July 29, 2022

City of Mercer Island – Community Planning & Development
Mercer Island, WA 98040

Project: **2205-232-INTAKE1 | ROSS-PARKS RESIDENCE**
7010 93RD AVE SE, Mercer Island, WA 98040

Please accept this letter as a formal response to INTAKE1 notes, dated June 15, 2022 to the residential remodel & addition Application, submitted May 12, 2022. My hope is that we have addressed all comments, and that your application review may continue.

TOPOGRAPHIC & BOUNDARY SURVEY
SW 1/4 OF NE 1/4 SEC 30, TWP. 24N., RGE USE., W.M.
PARCEL NO. 258190-0300

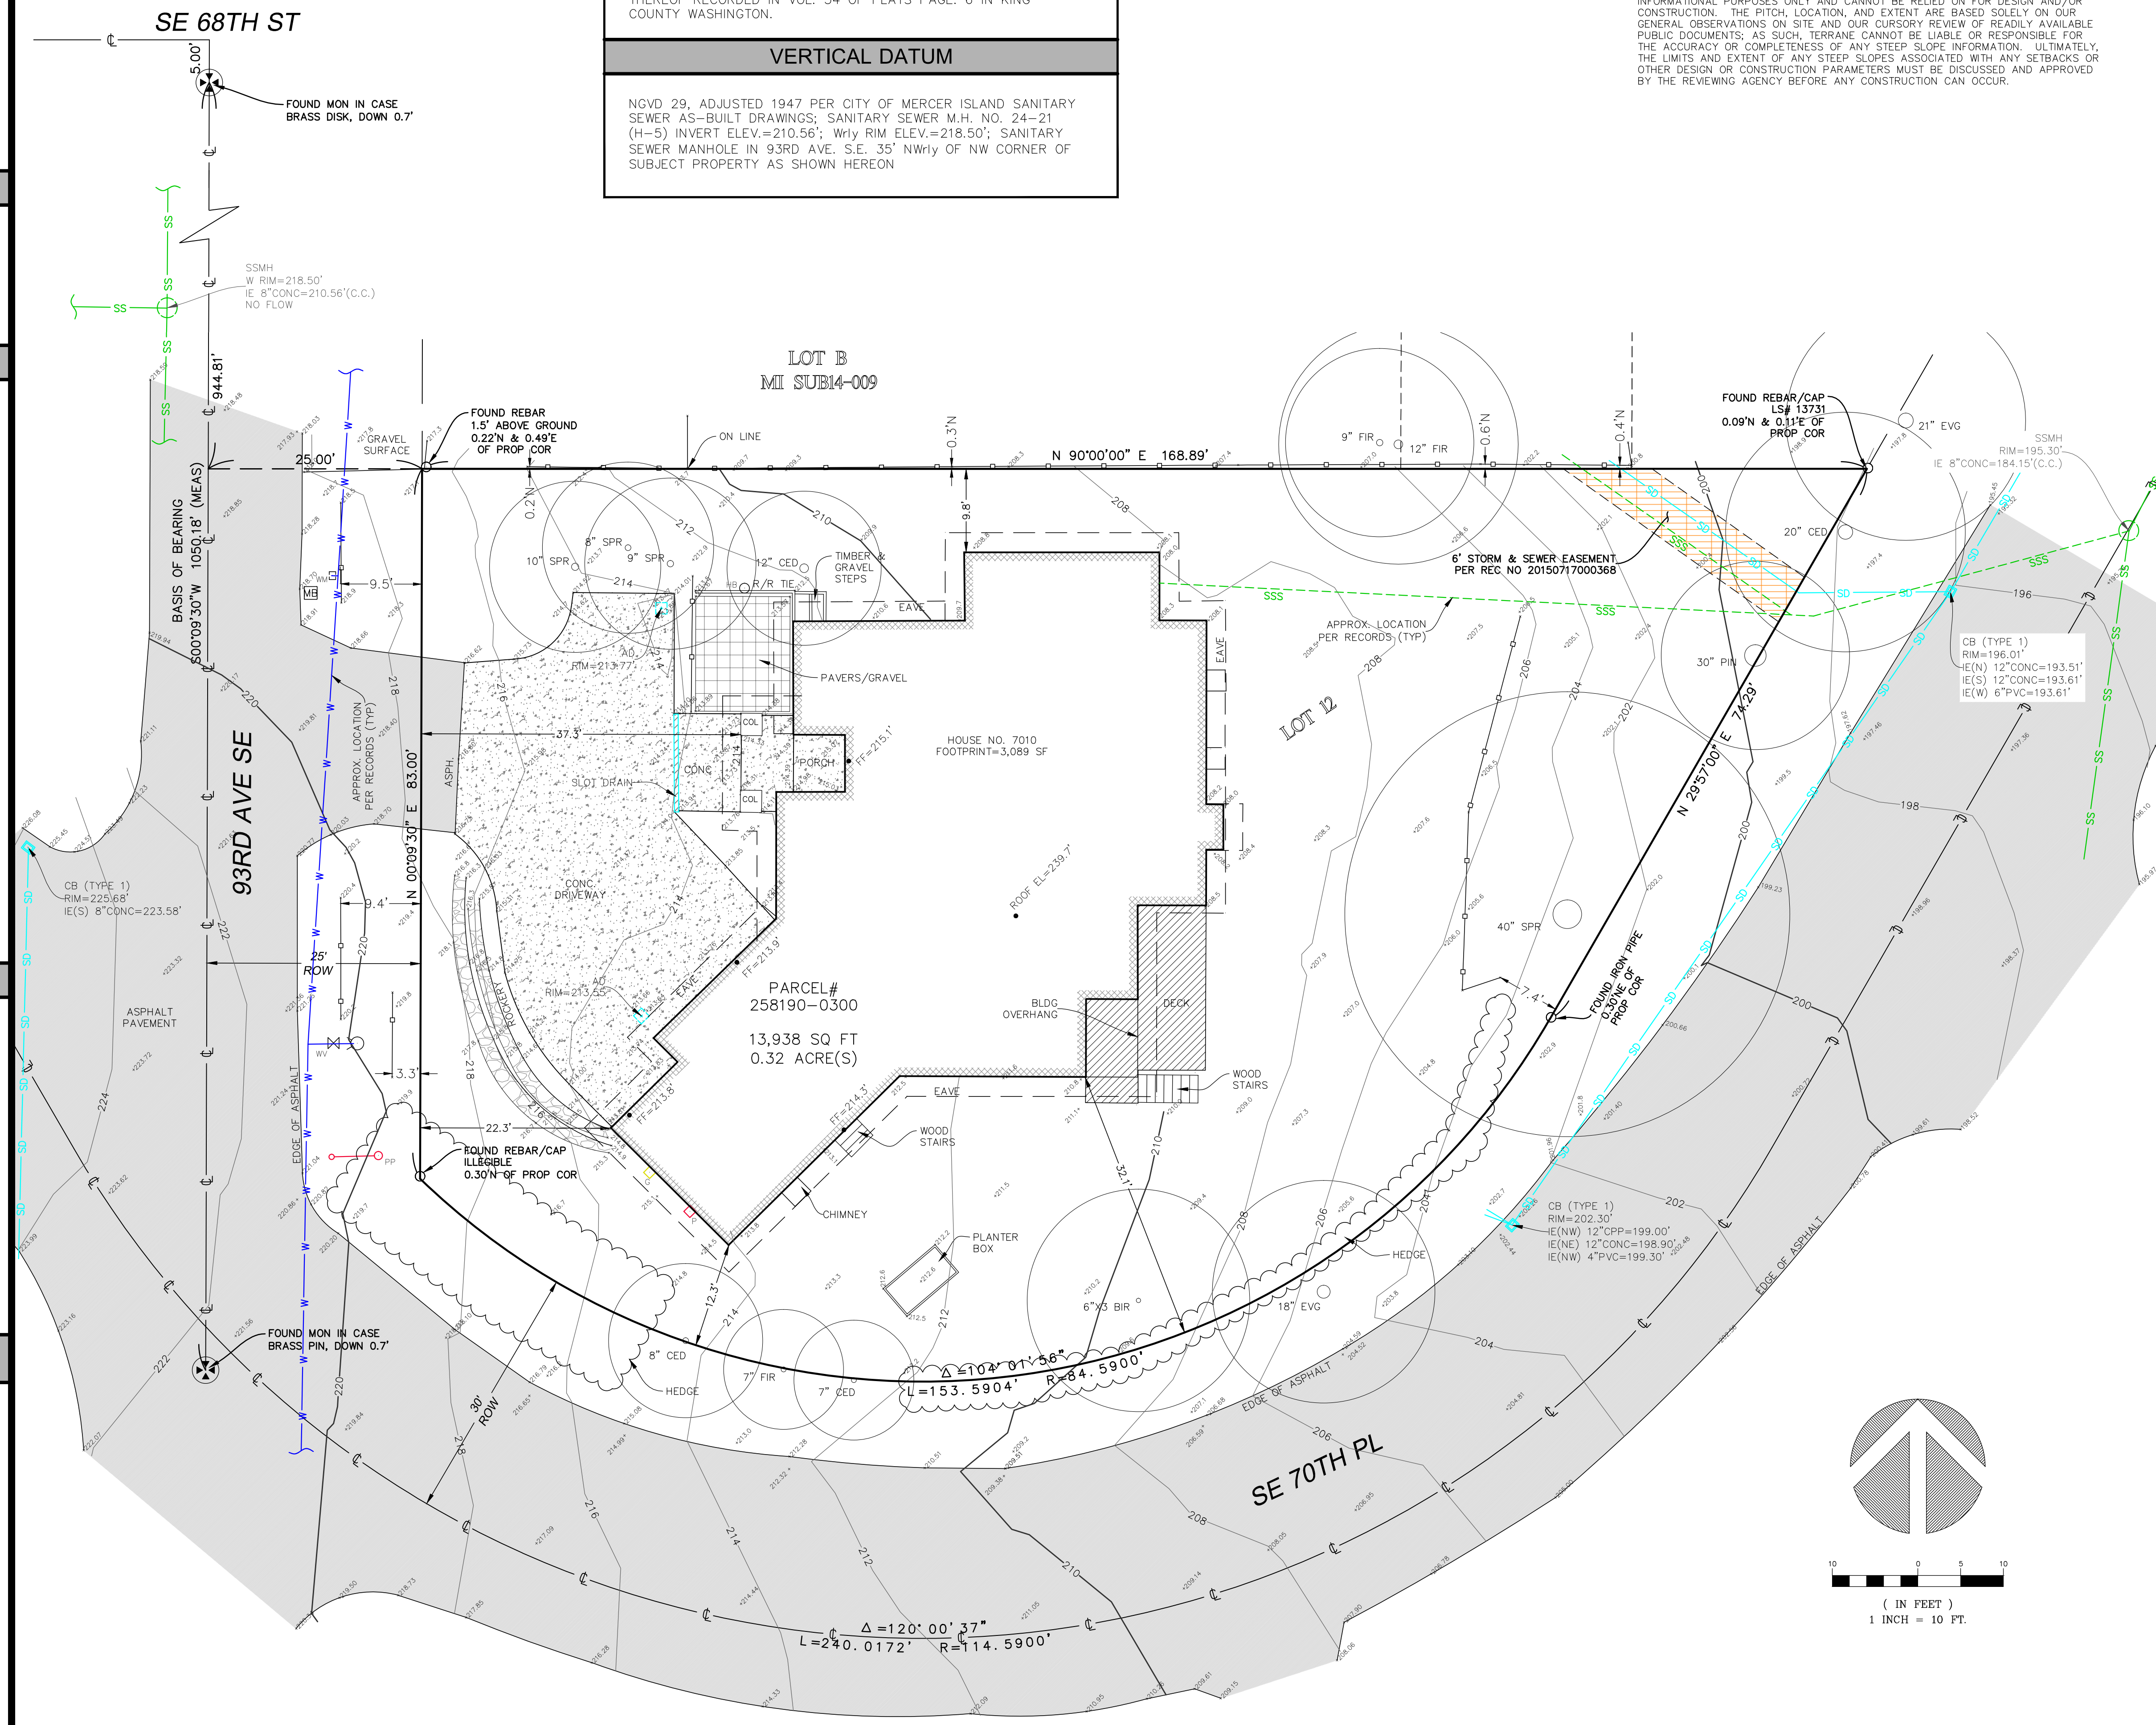
- Sheet A1.0 shows that the existing gravel path and paving area is exceeding 500 sf, but the survey drawing does not show the gravel area as being an existing area. Please clarify. If gravel area is a new area, then the net increase of impervious surface areas will exceed 500 sf. A full drainage plan and drainage report prepared by a licensed civil engineer are required.
 - The net increase of impervious surface area will not exceed 500 SF. Detailed calculations of the gravel area and overall impervious surface of related to the proposed addition can be found on sheet A1.0. In conclusion, a full drainage plan and report will not be required.

A1.0

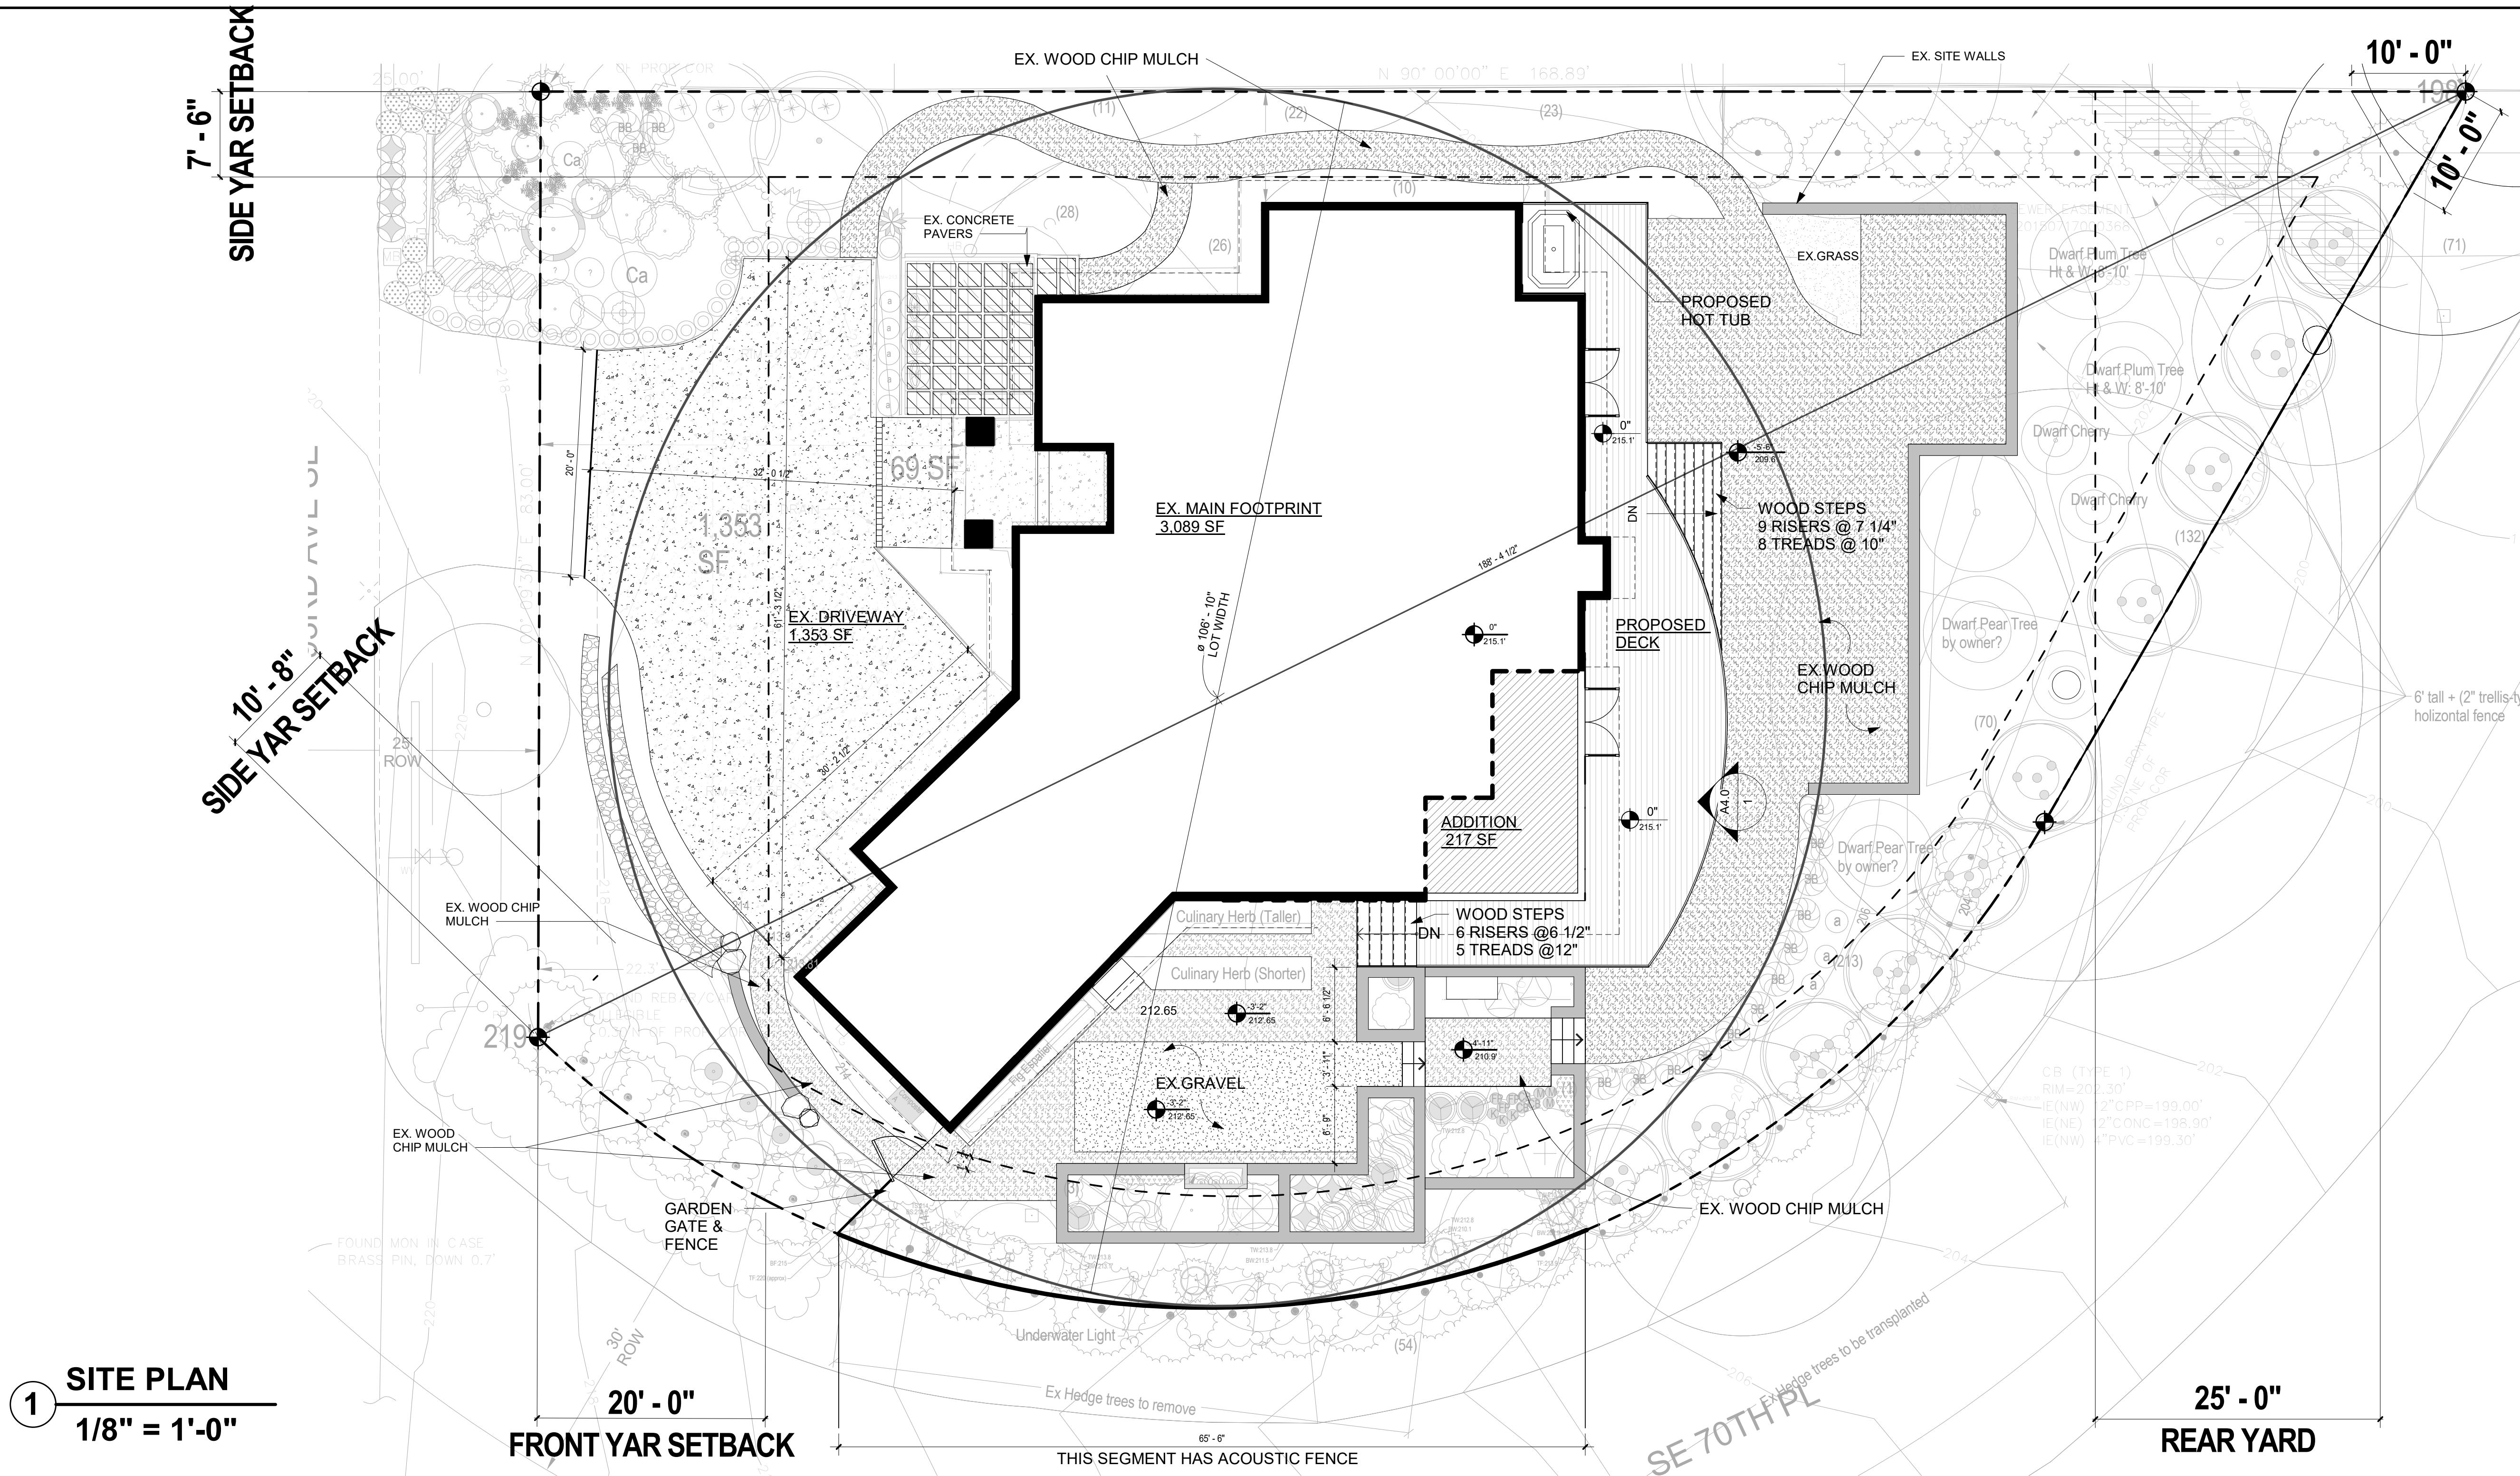
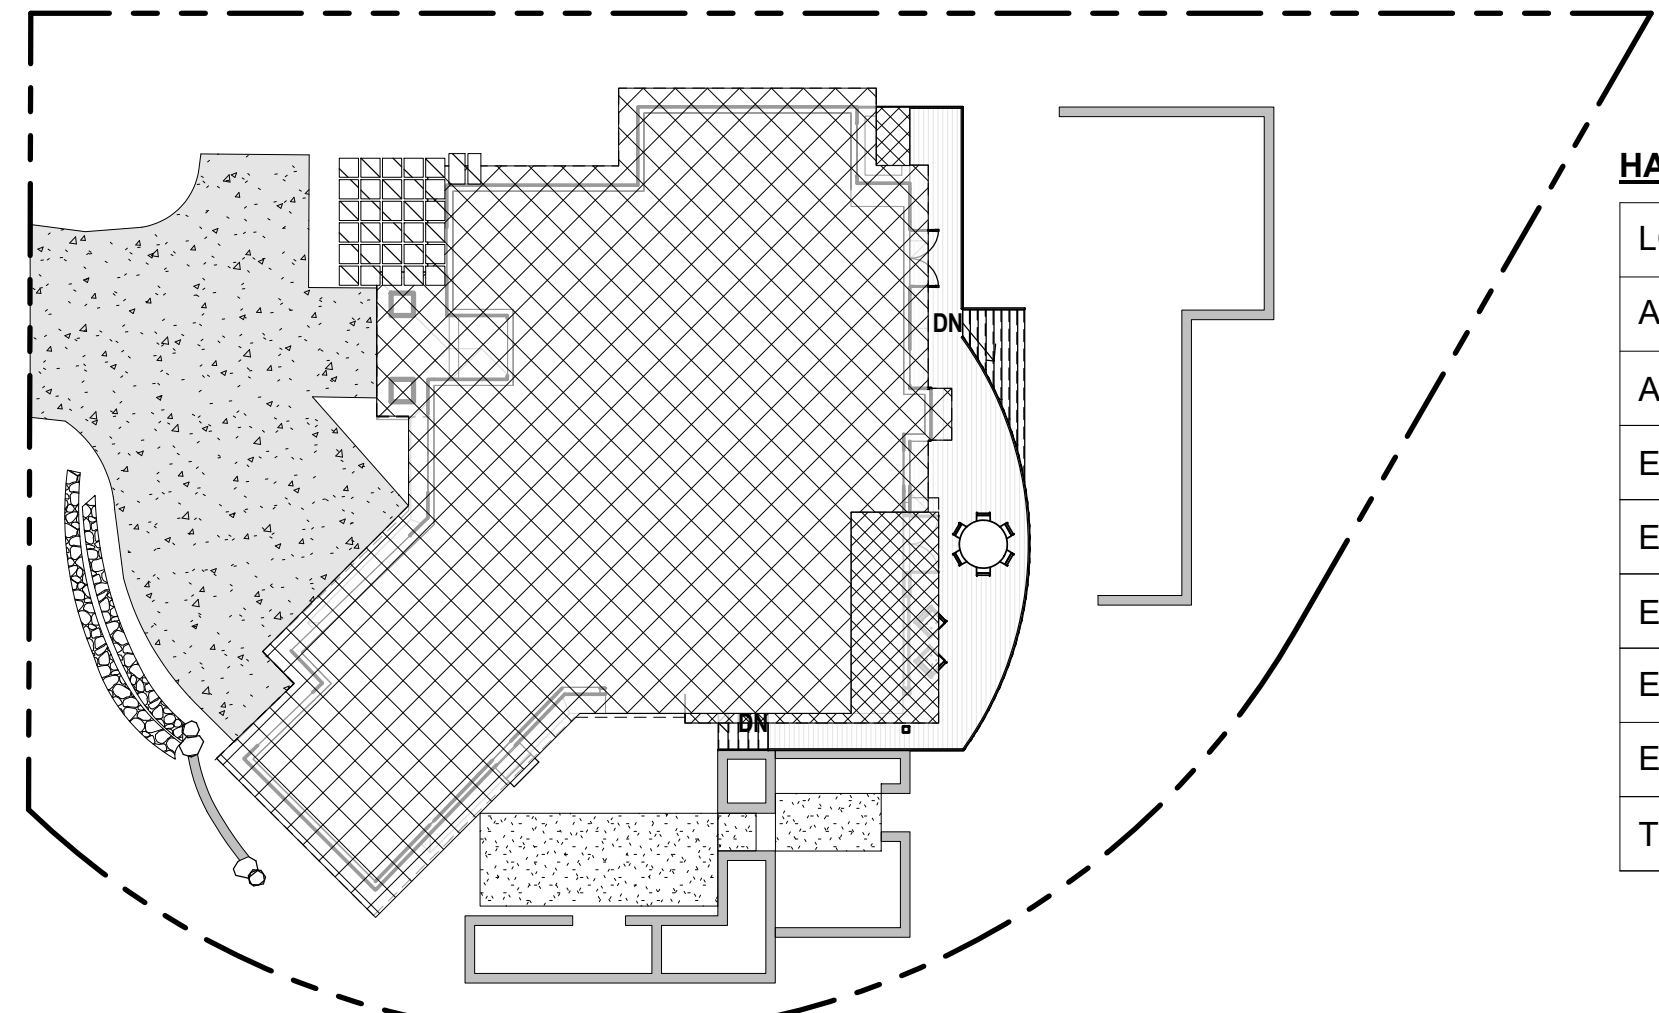
- The proposal involves alteration of a geologically hazardous area. A separate land use application for a Critical Area Review 1 needs to be submitted for this project.
 - The Critical Area Review 1 application will be submitted.
- This lot is considered an irregular lot. As such, the lot's width must be determined using a lot width circle. The lot width circle is the largest circle that can be drawn within the boundaries of the lot. The lot width is the diameter of the lot width circle. Please show the lot width circle on the site plan
 - Revised & noted on sheet A1.0
